U-5706 - CP 4B Meeting-20260916_130234-Meeting Recording

September 16, 2026, 5:02PM

New location between US 74 and US and Roverdale Road. Each end of the project is a three-lane section. And we're on segment one right now. This project will break it up into two segments. Segment one and segment 2 are kind of earmarked on the end. Those are the three lane sections. And then we're coming back with segment 2, which is majority of the new location sections. But section 2 will have the first or the second intersection, which is Y2 County Home Road.

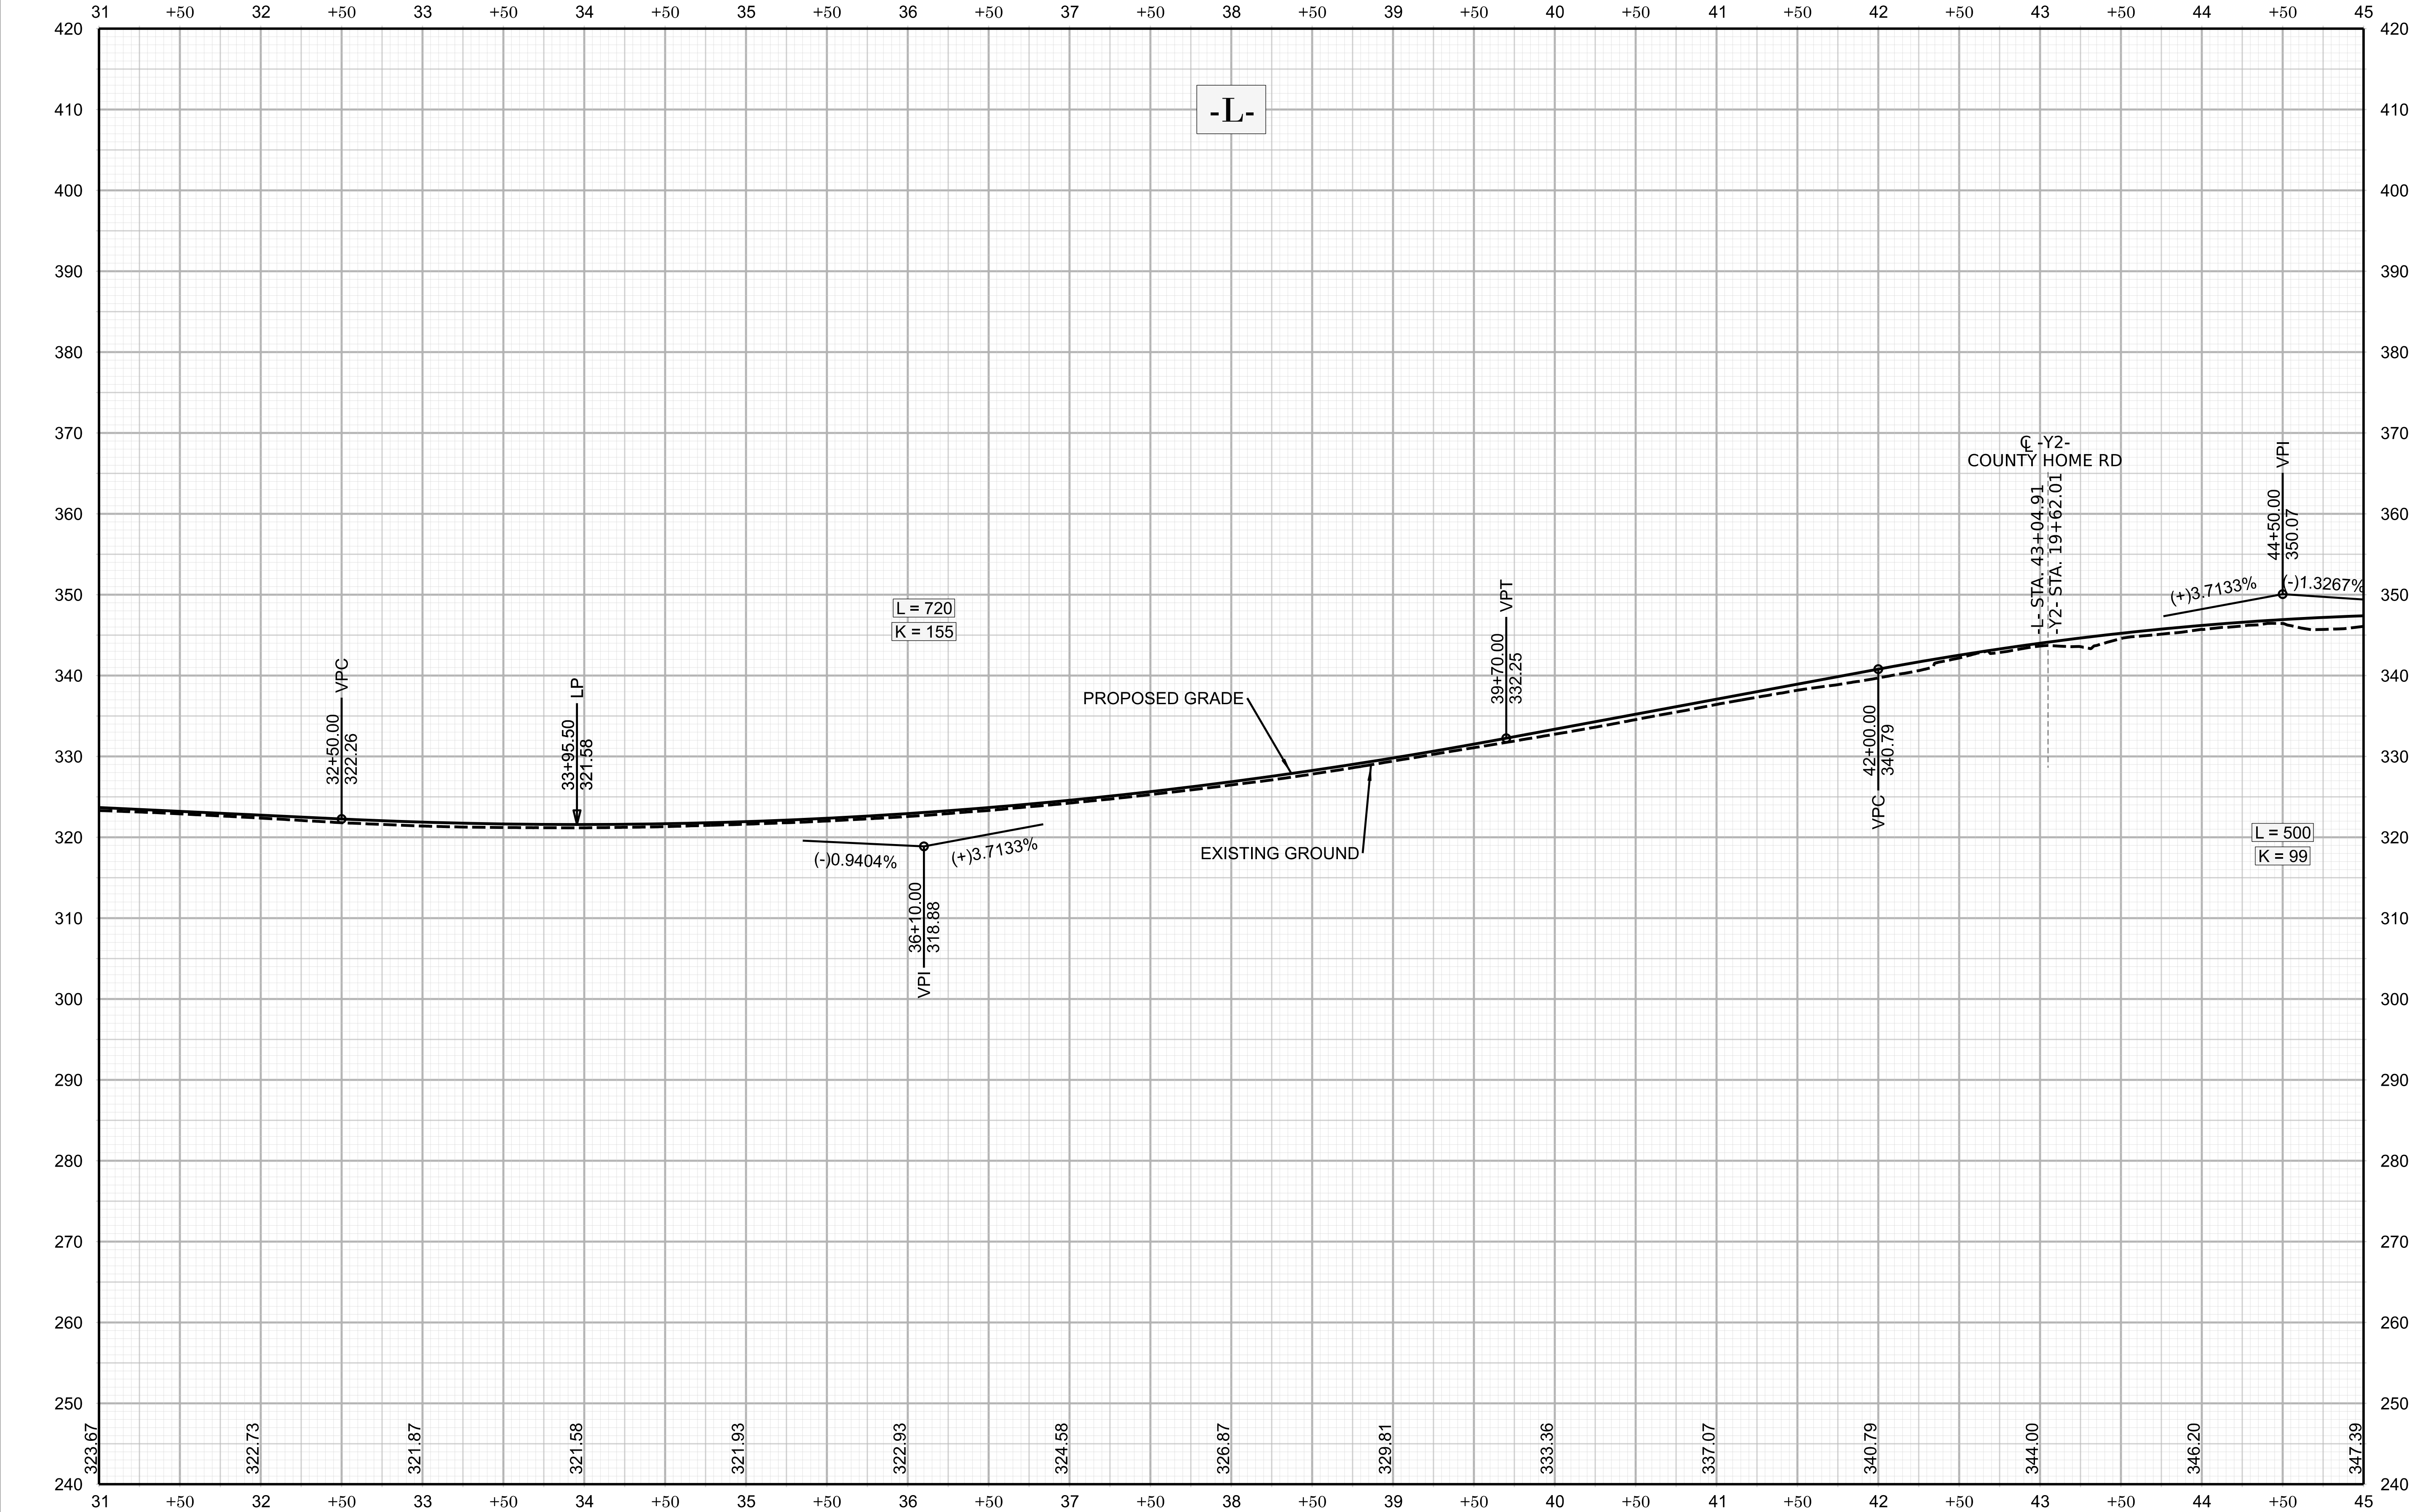
Uh, Robin W.I. might just be, for my knowledge, as I'm new to the project, but the bill slope and drainage does seem to go pretty far into the wetland away from the road. I was wondering if that could is, I don't know what the slots are. I'm sorry, you know that 31 Christine or are they?

We had just noticed it pulled in on other parts of the project, and we're curious why it hadn't been done here, but it, yeah, it depends on the height of the road. Yeah, yeah, the higher the road, the further it's gonna go out.

So we did pull it in in this section. So it switches from 4 to 1 to 3 to 1 at station 172.

Correct, correct. We could probably make it 3 to 1 through the entire wetland.

So we could probably just take the fill slope at 171 50 just past the driveway, make that three to one and then hold the three to one until we get out of the wetland.

Three to one is the max fill slope based on geotechnical recommendations.

from the preliminary geotech recommendations. So we are getting more detailed geotech recommendations that may allow for a two-to-one fill slope.

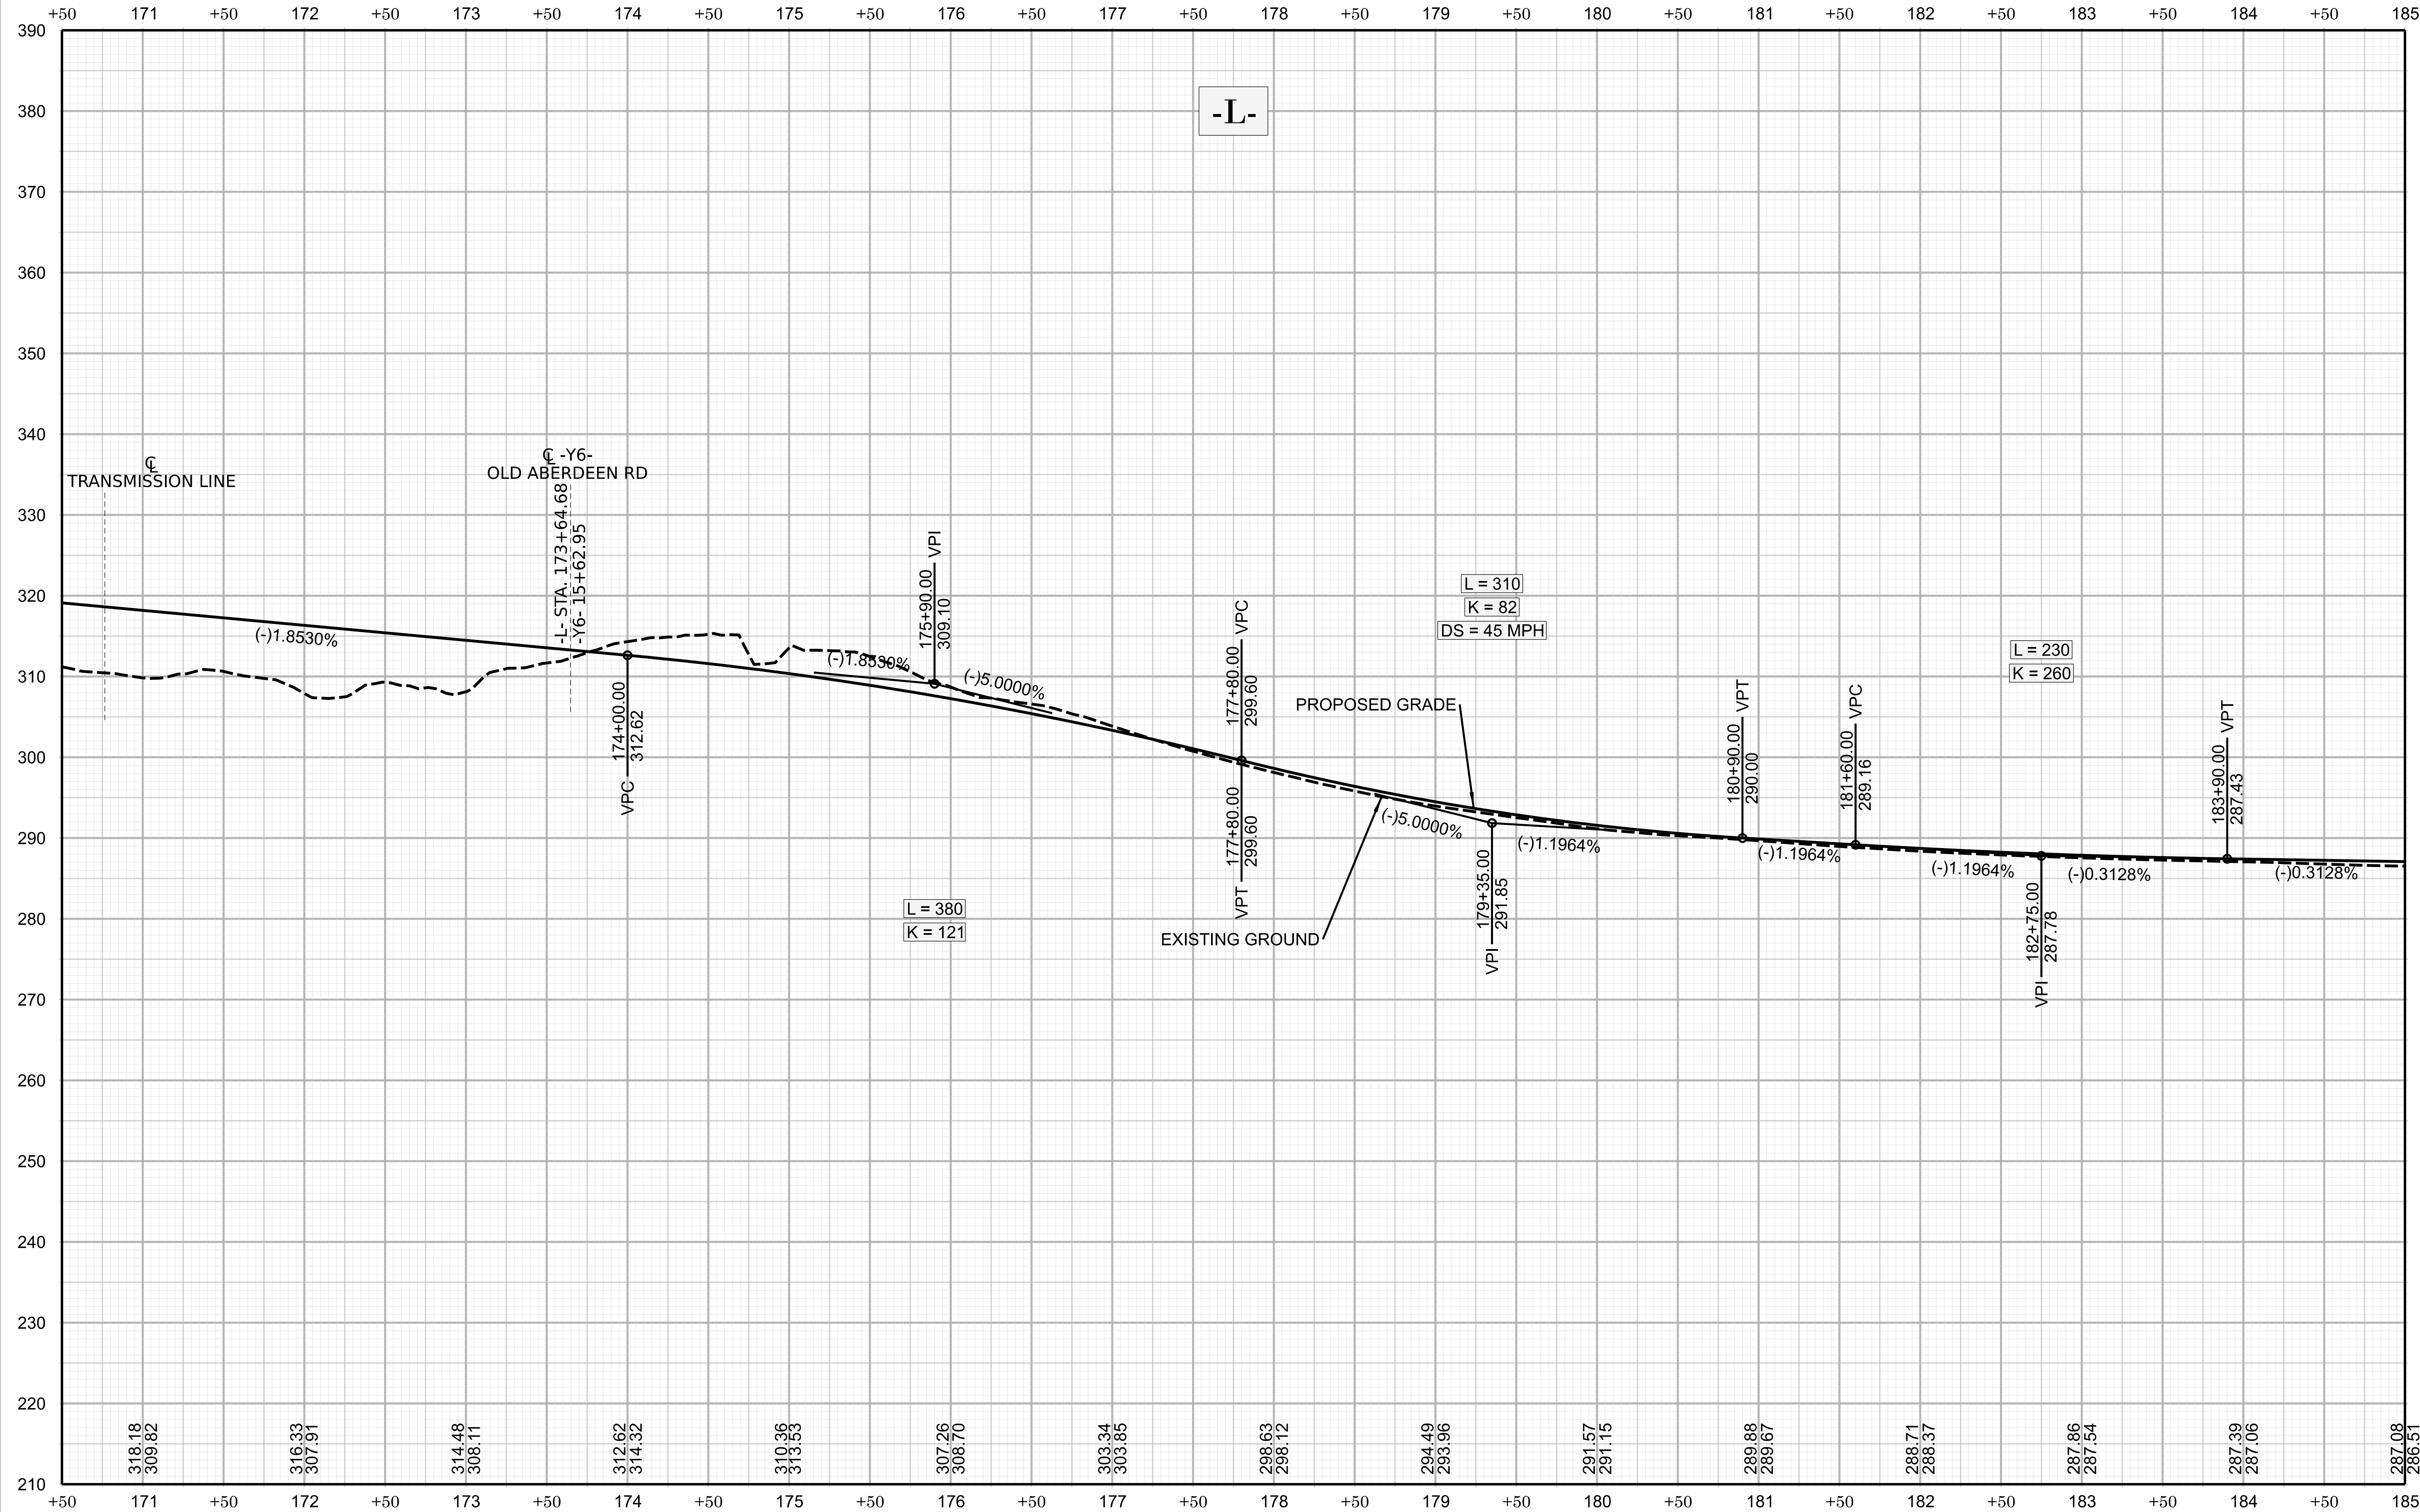
I did have a question here. And it kind of led me down a rabbit hole. So you have to bear with me a little bit here. I was looking at that area between the two cross pipes, the two 24 inch cross pipes, and I saw a wetland symbol in there. And I didn't see a dotted line around that.

Wetland WAAN on my delineation is that I I sent out was pretty pretty narrow like that one is. It's got a little area there there off to the side.

And all that is on the north side of the existing Rd. And it doesn't look like WAN travels. And I'm turned around here direction wise, whether that's to the south or not, but towards WAM. So I don't know if that got picked up from I'm not sure where that's coming from. You might, and I would, but I would ask you to verify that area right there where your cursor is. If that got pulled in somehow, or...

Yeah, that was the only reason it caught my eye. And then I started doing a little digging. So that one warrants some, and I think that's, is that station near station 180. Yeah. Take a look at that and see if that's something that came from something preliminary or something prior to the JD being issued.

Yeah, I don't know what happened there, but that's the file I already received did not have any type of blue dash one or other summons.
